RE: New Public School in Googong SSD RFI

Reference is made to the response submissions from the Department of Planning, Industry and Environment (DPIE), - Queanbeyan-Palerang Regional Council and Transport for NSW (TfNSW) with respect to SSDA submission for the new school in Googong (Reference SSD – 10326042).

Table 1 DPIE RtS Letter

APPENDIX C – SWEEPED PATHS (12.5M RADIUS)

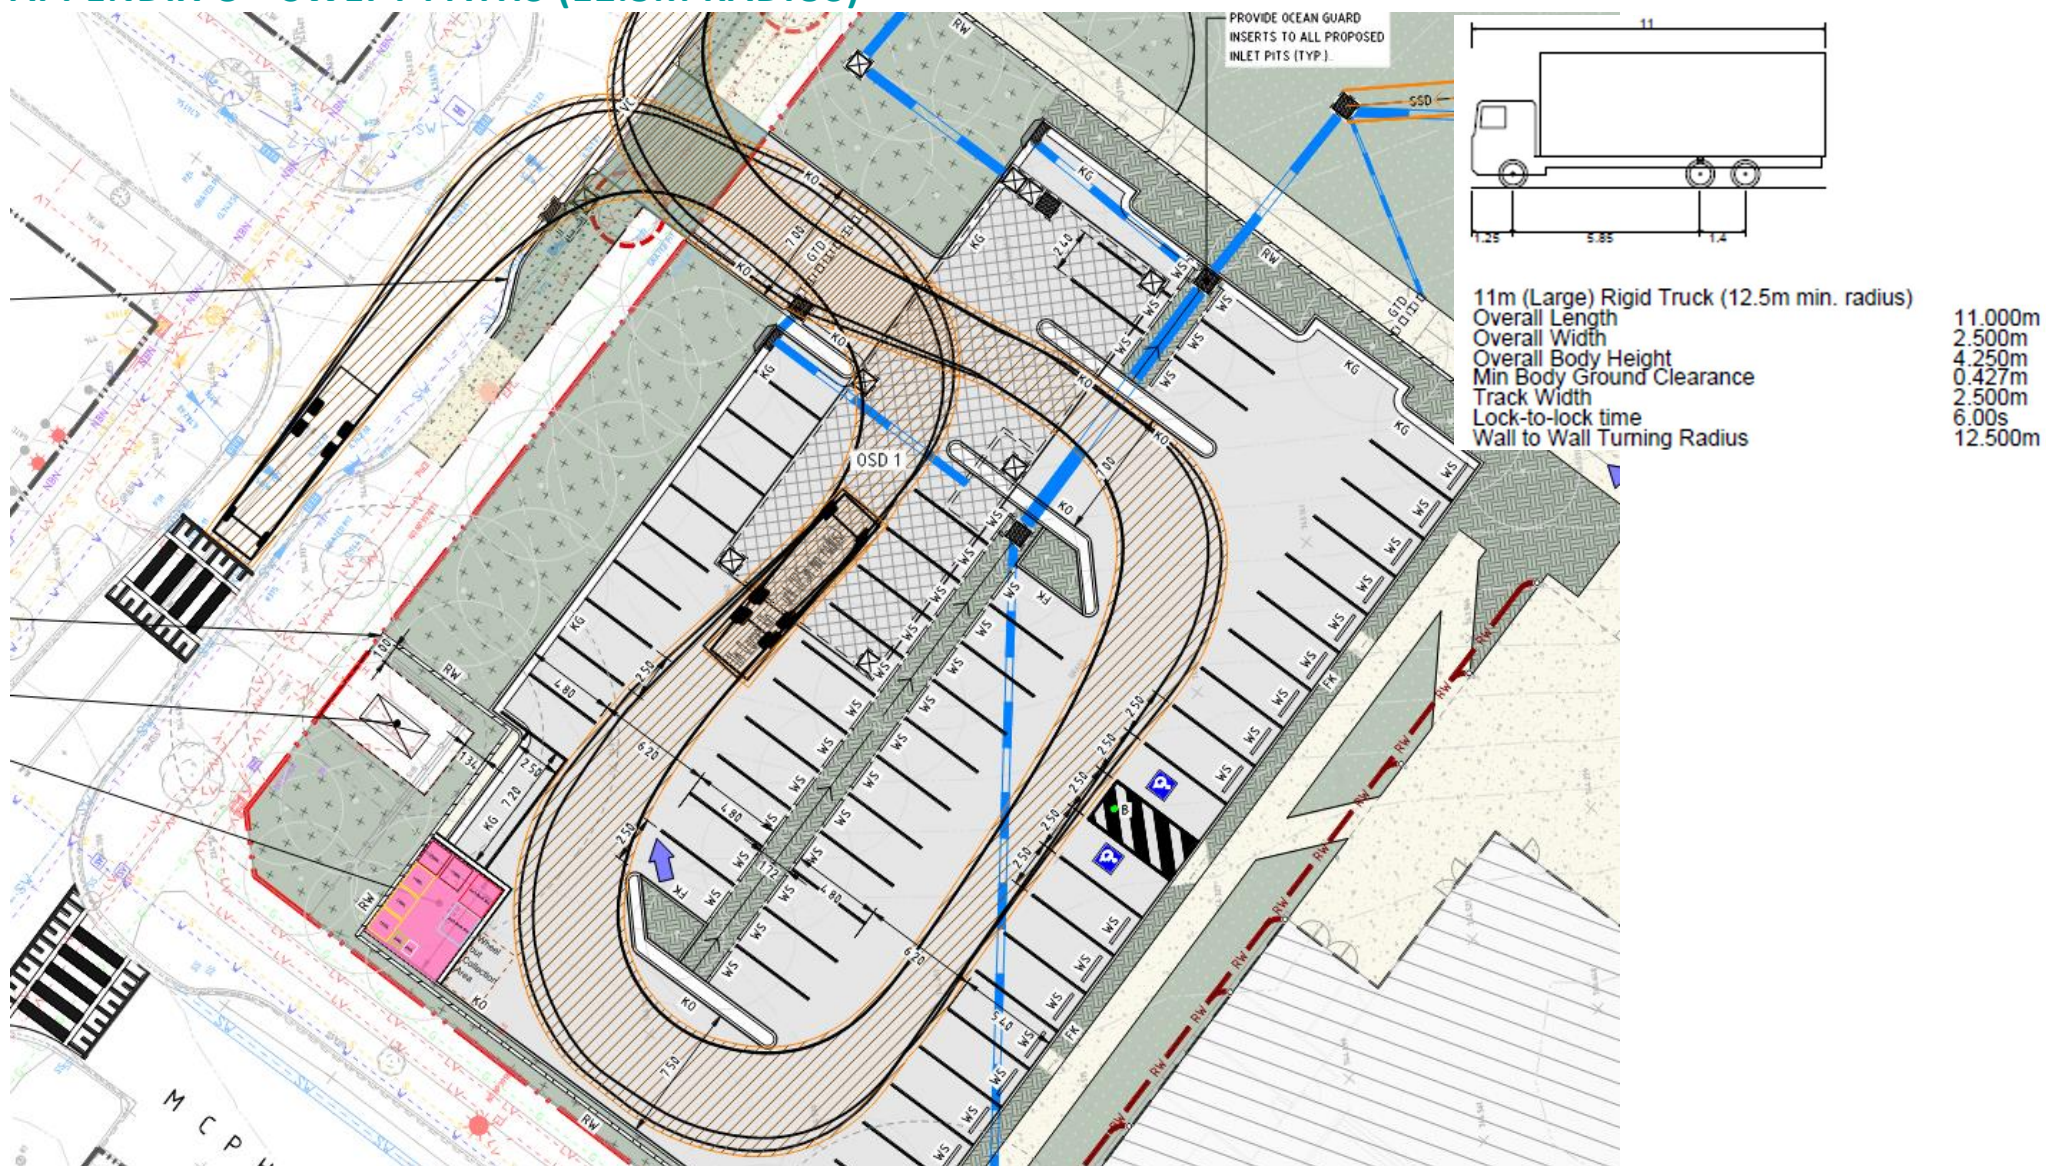
1.6	<p>The following figure has been extracted from the information provided. It shows that the driveway for the proposed waste vehicle swept path is not wide enough to cater for its entry and exit. The vehicle crossing should be widened or location adjusted to prevent damage to Council infrastructure.</p>	<p>The civil design for the vehicle crossing has been revised to QPRC standards (DS5-01) to allow for access as shown without impacting on kerb and gutter.</p>
